APPROVAL OF RESERVED MATTERS

Application Reference: DC/23/00024

Application for approval of Reserved Matters pursuant to Outline Planning Permission DC/23/00082 - Appearance, Landscaping and Scale for Severance of garden and erection of 2No dwellings

Orchard Haven, All Saints Road, Creeting St Mary, Ipswich Suffolk IP6 8PJ

Drawing number
22168 101 rev A

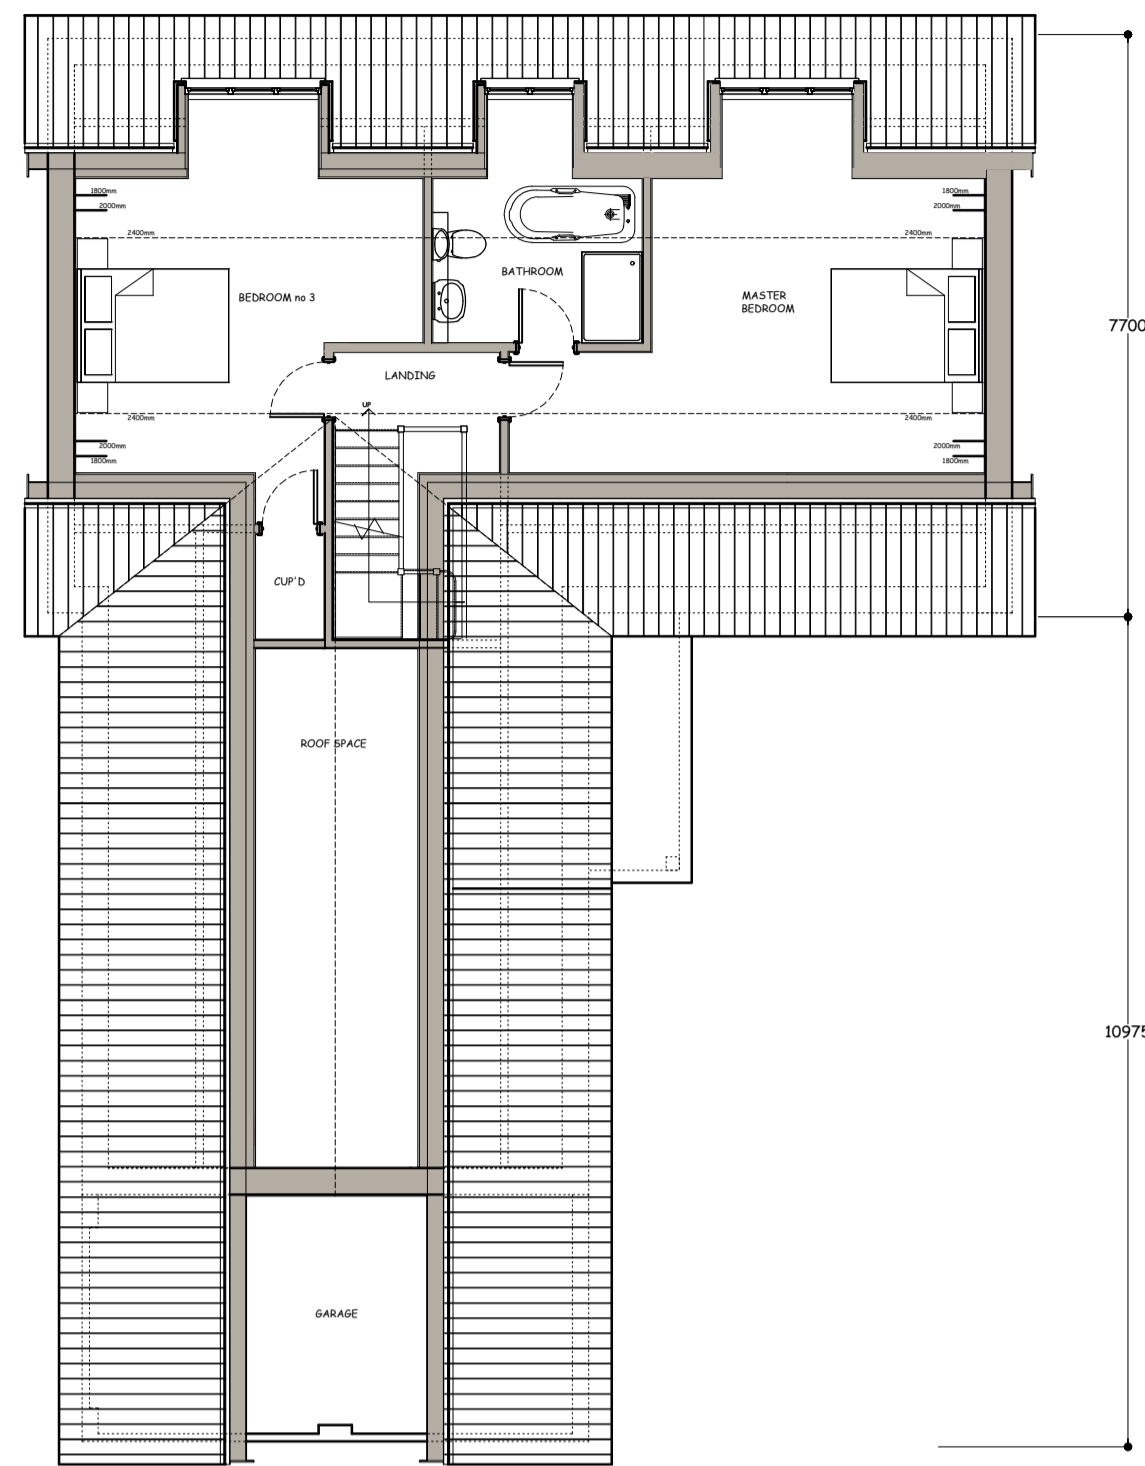
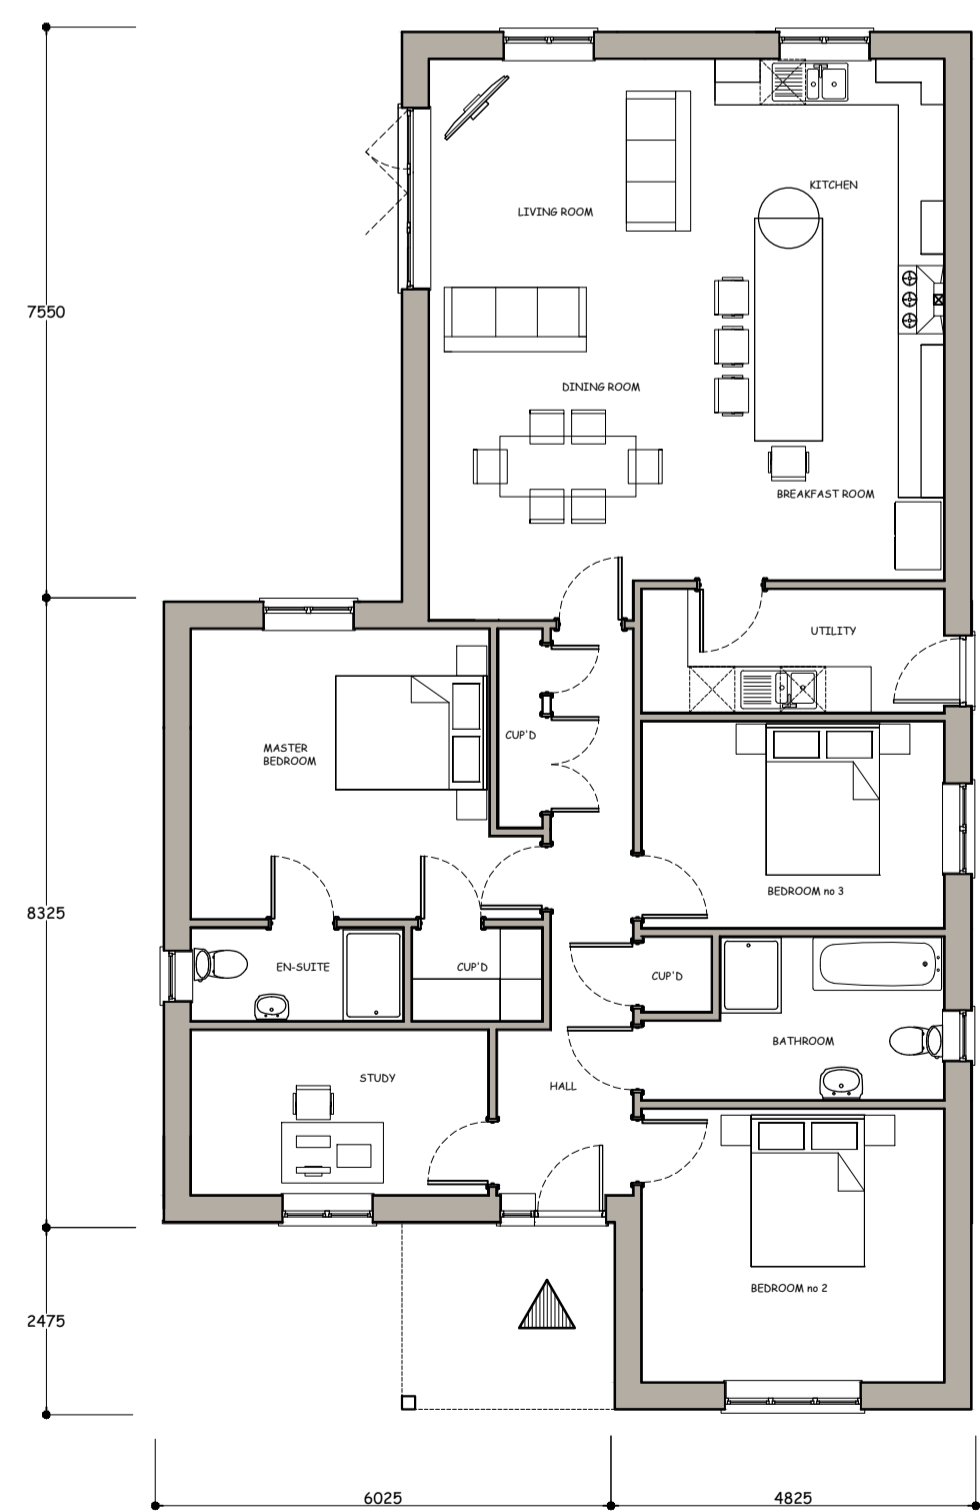
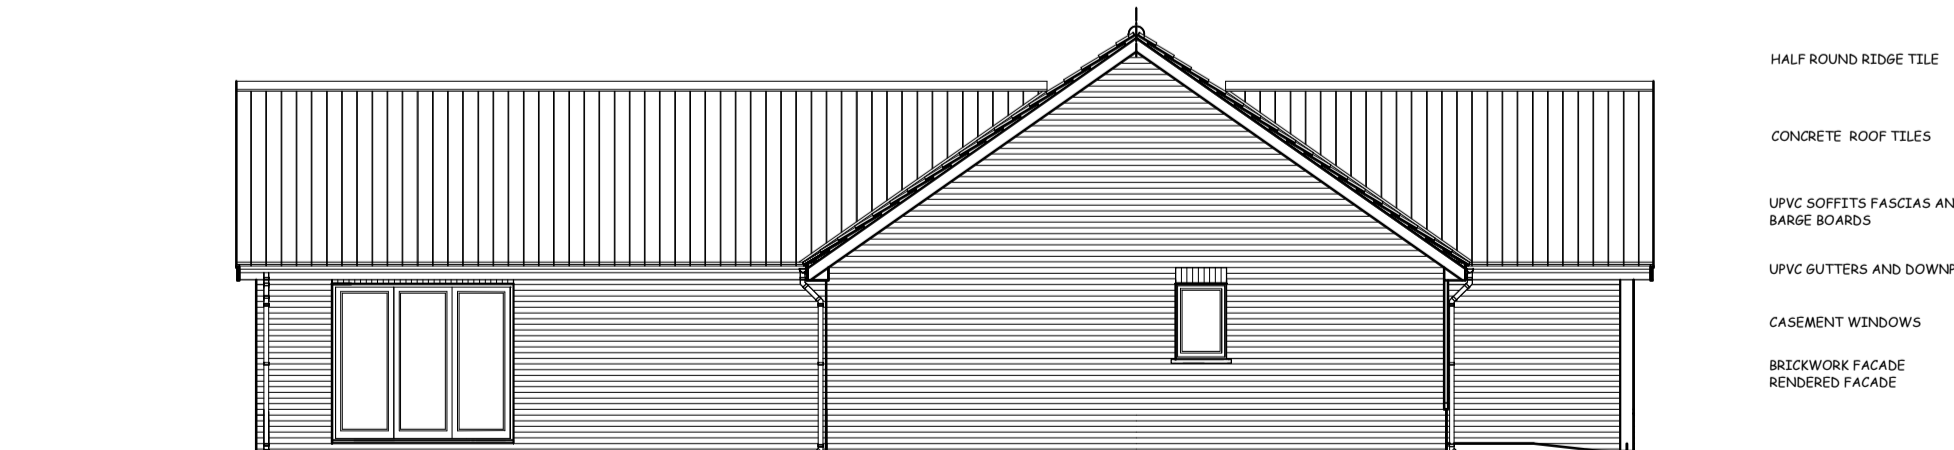
Notwithstanding the materials shown on plan 22168_101, the development hereby permitted shall be carried out in accordance with the drawings/documents listed under Section A above and/or such other drawings/documents as may be approved by the Local Planning Authority in writing pursuant to other conditions of this permission or such drawings/documents as may subsequently be approved in writing by the Local Planning Authority as a non-material amendment following an application in that regard. Such development hereby permitted shall be carried out in accordance with any Phasing Plan approved under Section A, or as necessary in accordance with any successive Phasing Plan as may subsequently be approved in writing by the Local Planning Authority prior to the commencement of development pursuant to this condition.

4. Please note that the use of concrete roof tiles is not appropriate on this site and the materials are therefore not approved. Should they be proposed as part of the future discharge of conditions application, they will not be supported. You are advised that clay pantiles would be more appropriate, particularly in the setting of a listed building.
